UK Health
Security
Agency

**Nationally Significant Infrastructure Project
Keadby 3 Low Carbon Gas Power Station, DCO, Statement of Common Ground,
PINS Reference EN010114**

With regards to the Statement of Common Ground (SoCG) (revision VP3.0, dated April 2022, received 26th April 2022), we note that we have replied to earlier consultations as listed below following receipt of an initial draft from the applicant on 10th December 2021 (VP1.0, dated December 2021).

SHEET 7 OF 10 - LAYOUT VIEW TWIN ABSORBER

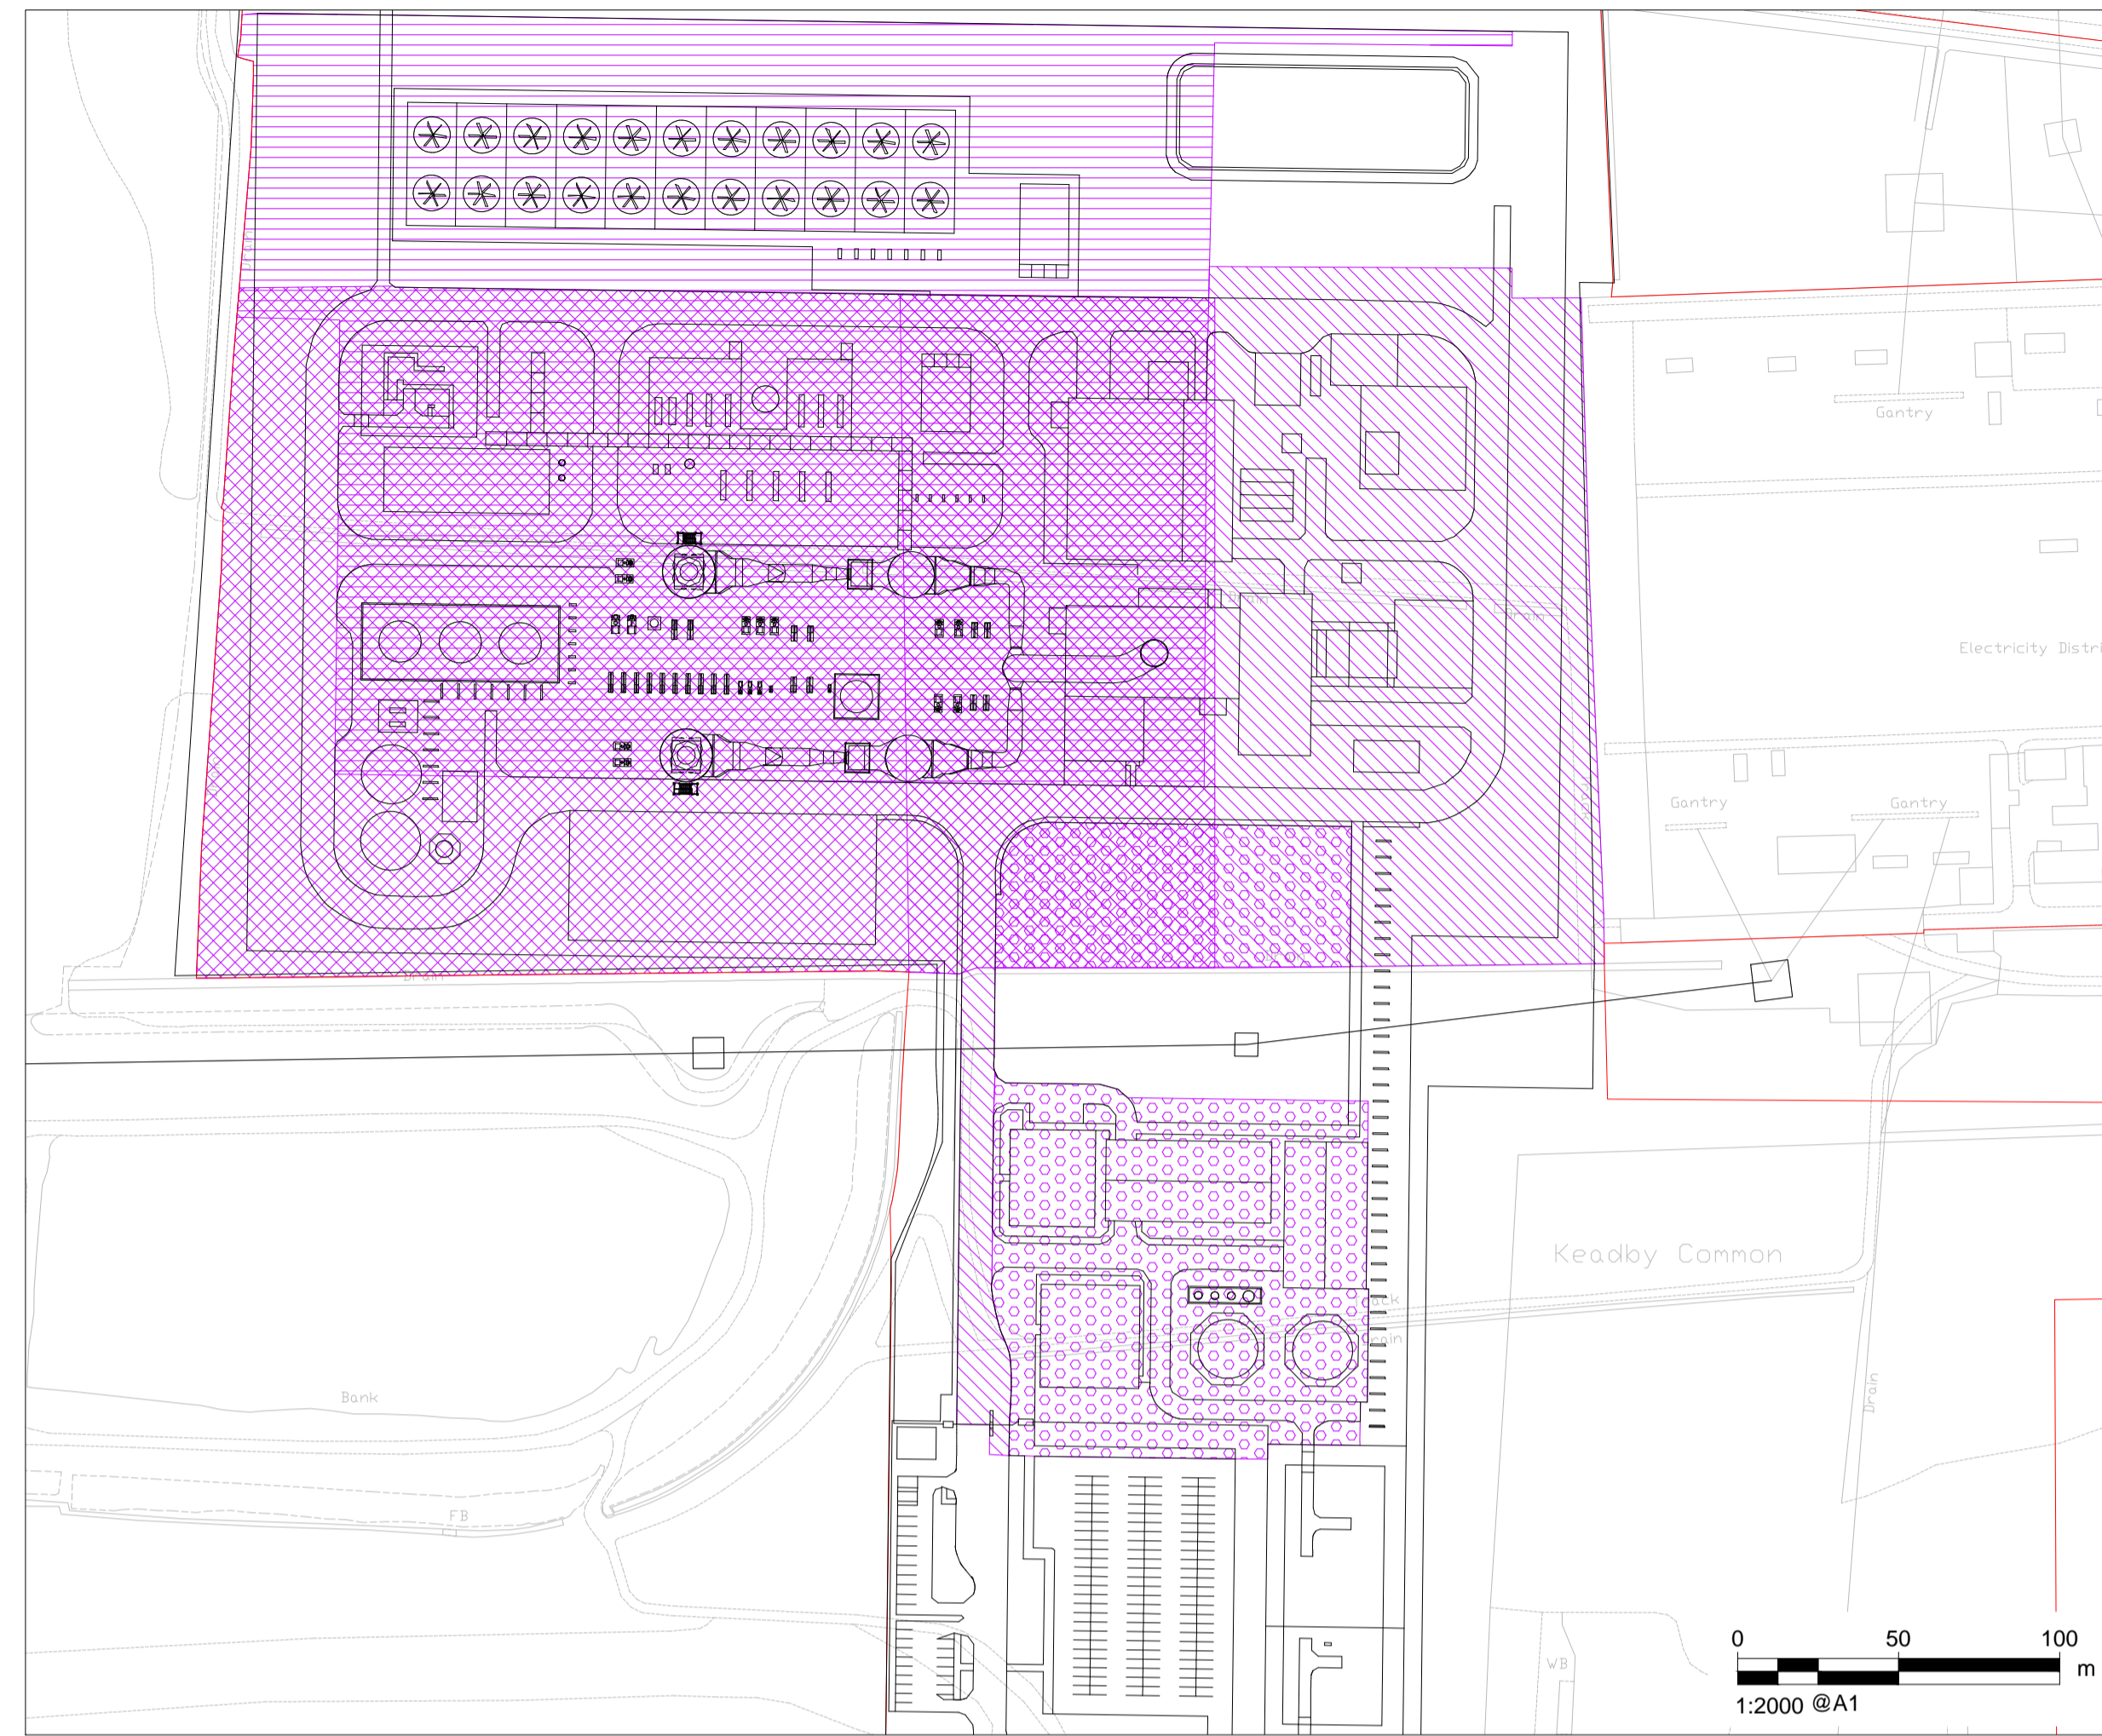
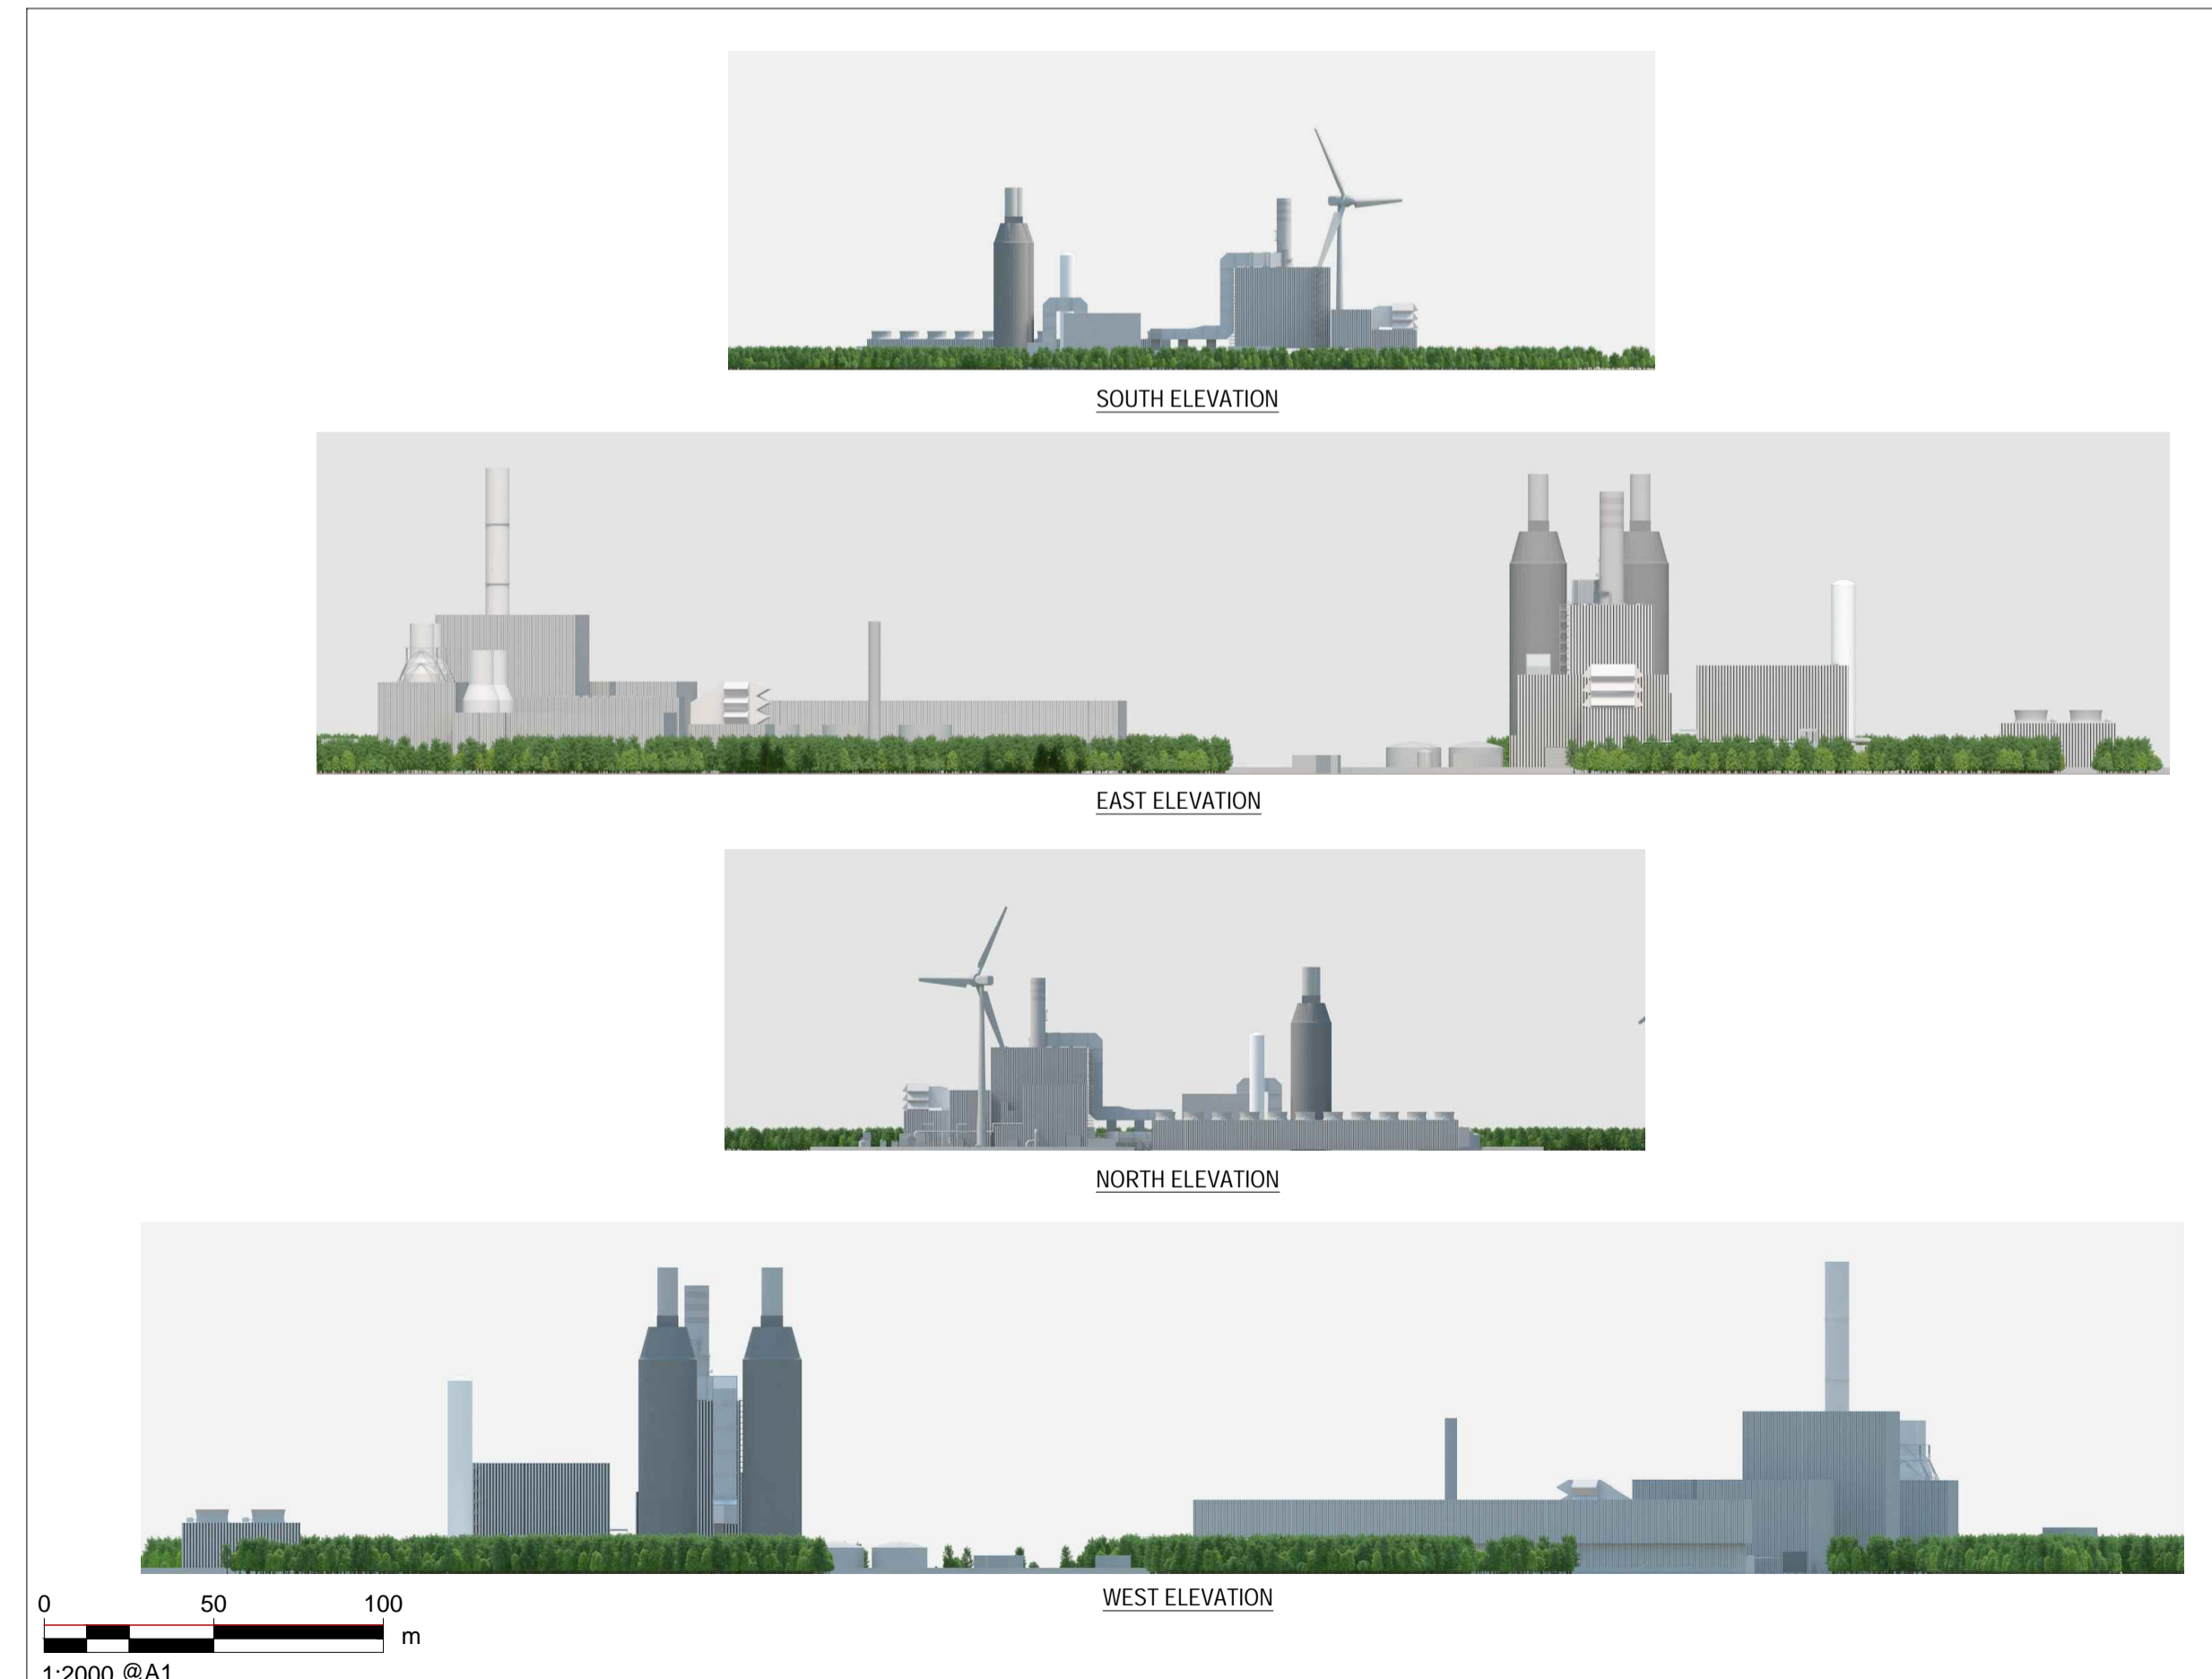
However, UKHSA considers that insufficient information has been submitted in support of the public health risk assessment. We recommend that modelled outputs of concentrations of pollutants from stack emissions at human health receptors be provided in support of the conclusions in the above paragraph so that UKHSA can satisfy itself that the worst-case modelled data do not change from those detailed in the originally reported.

It is unclear why modelling has not been undertaken for a range of stack heights for the twin absorber scenarios to inform the public health impact assessment and stack design. Further justification for this approach is recommended. Reducing public exposures to non-threshold pollutants (such as particulate matter and nitrogen dioxide) below air quality standards has potential public health benefits. We support approaches which minimise or mitigate public exposure to non-threshold air pollutants, address inequalities (in exposure), and maximise co-benefits (such as physical exercise) and encourage their consideration during development design, environmental and health impact assessment, and development consent.
